From: Ian Hayward
Sent: 28 October 2021 07:34
To: Amber Willard
Subject: RE: Mildmay, Hook Lane, Aldingbourne, PO20 3TE

To expedite a response please accept this email as a formal 2nd consultation response.

West Sussex County Council was consulted previously on highway matters for this application and provided comments dated 28/09/2021. No in principle no highways concerns were raised however some clarification over the access matters were raised, namely how the existing access would serve the parking layout as demonstrated.

PLAN No K P 1

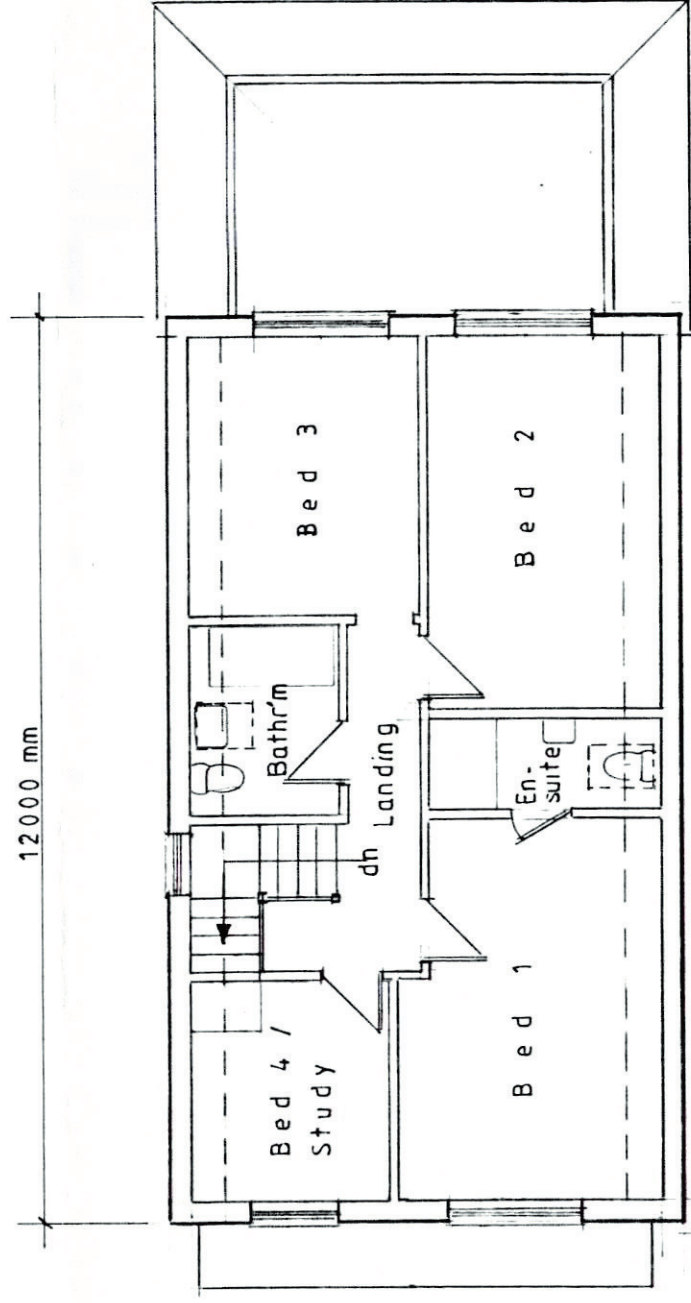
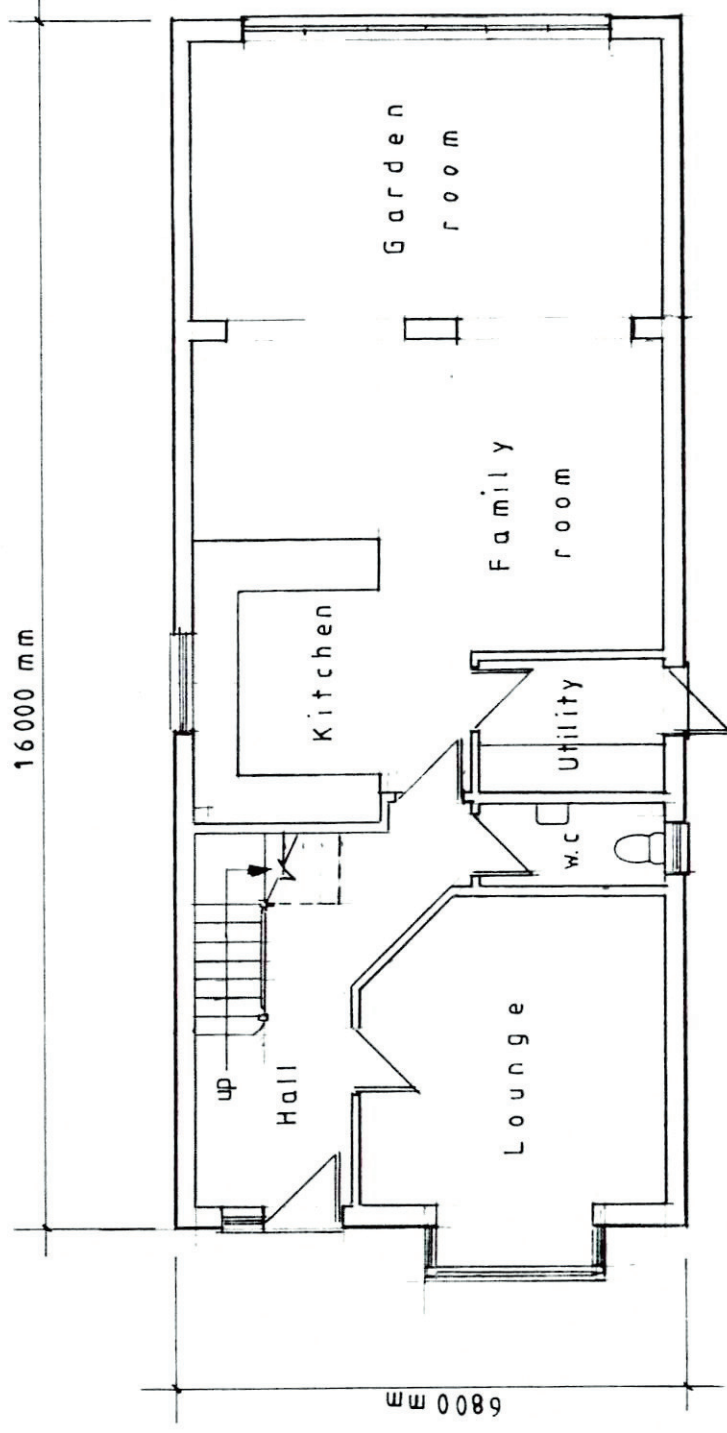
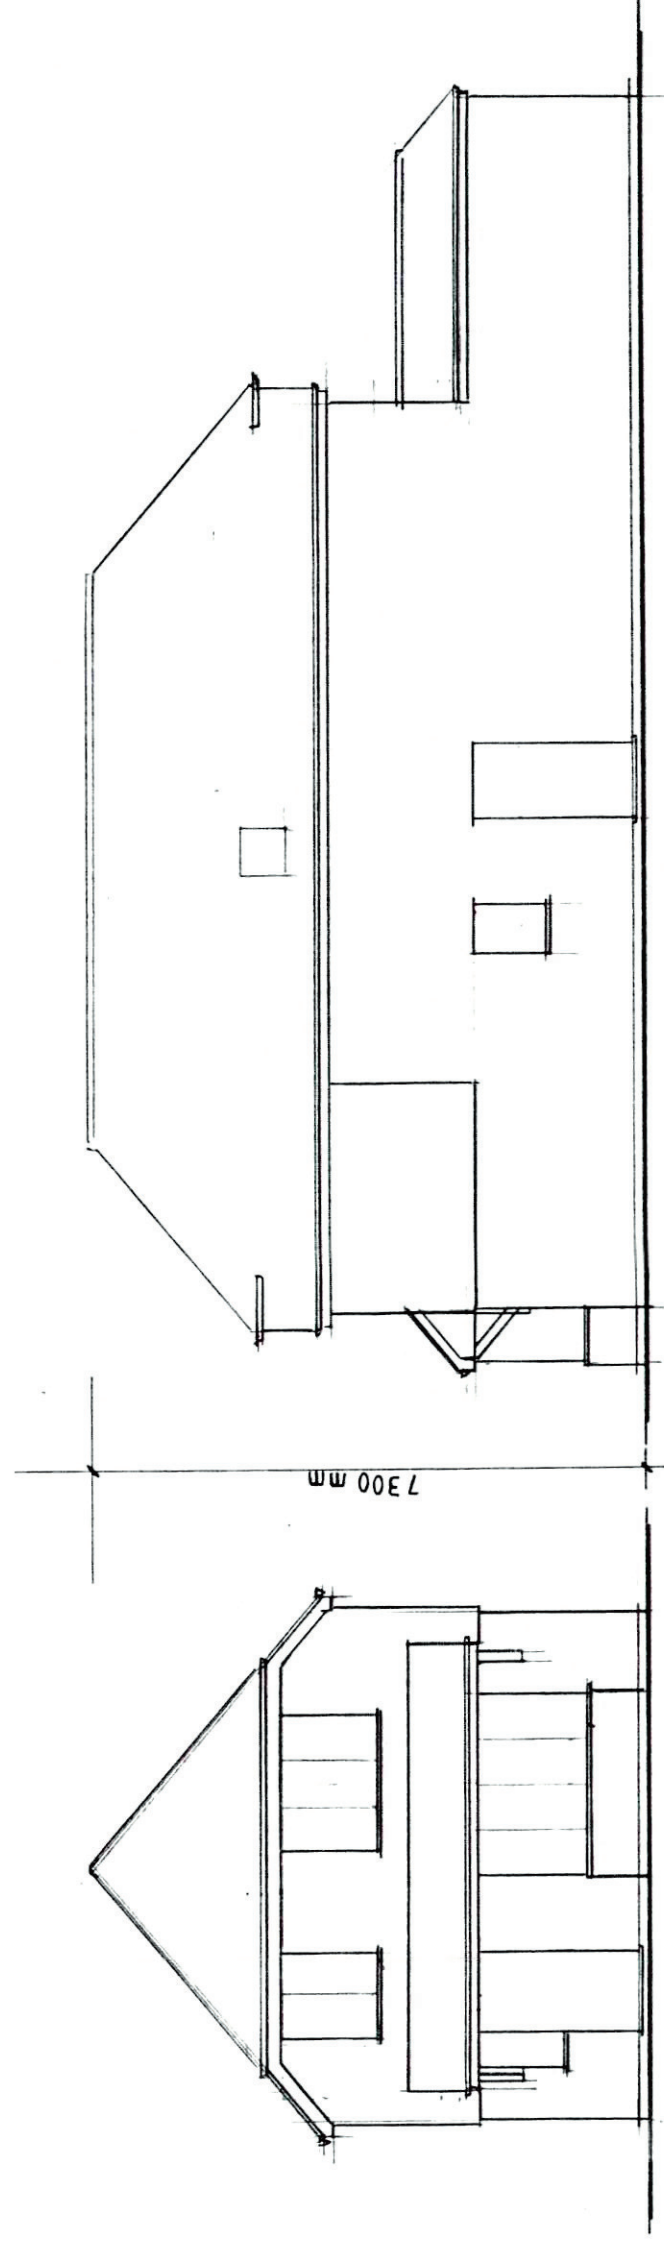
The applicant has confirmed via email that the access is to remain as existing. Given the access location has not been demonstrated on the site plans the Local Highways Authority are reliant on the use of google street view (see below), it is appreciated that this view is dated 2011 and may have changed but it shows the access at the southern extent of the property.

The site parking layout has been demonstrated as being 3 spaces parked perpendicular across the site frontage (see below). This parking arrangement does not seem achievable / accessible without alterations to the existing access point.

Without any further details being provided clearly demonstrating the access location, width and parking area the Local Planning Authority would be advised to consider this applications on the basis that only 1 / 2 car parking spaces are usable. The Local Highways Authority would not be in a position to substantiate that the additional created parking demand of 1 space would result in an unacceptable highway safety issue or severe cumulative residual impact upon the maintained highway network. The Local Planning Authority should therefore consider the amenity implications of the anticipated 1 space of displaced parking created by the development. If this was considered a concern the access could be relocated centrally within the plot, measuring no greater than 6.4 metres in width. These access works would need to be implemented under licence to a specification obtained from WSCC Highways. A suitable worded condition demonstrating the site access and an informative note would be required if this was the case.

As the Application details state there are no changes proposed to the existing access site arrangement. The parking arrangement does not need any access works and as the Application suggests none are proposed.

I can, therefore, confirm and clarify with you that no access works are proposed as part of this Application, the current situation as exists on site will serve the proposed development.
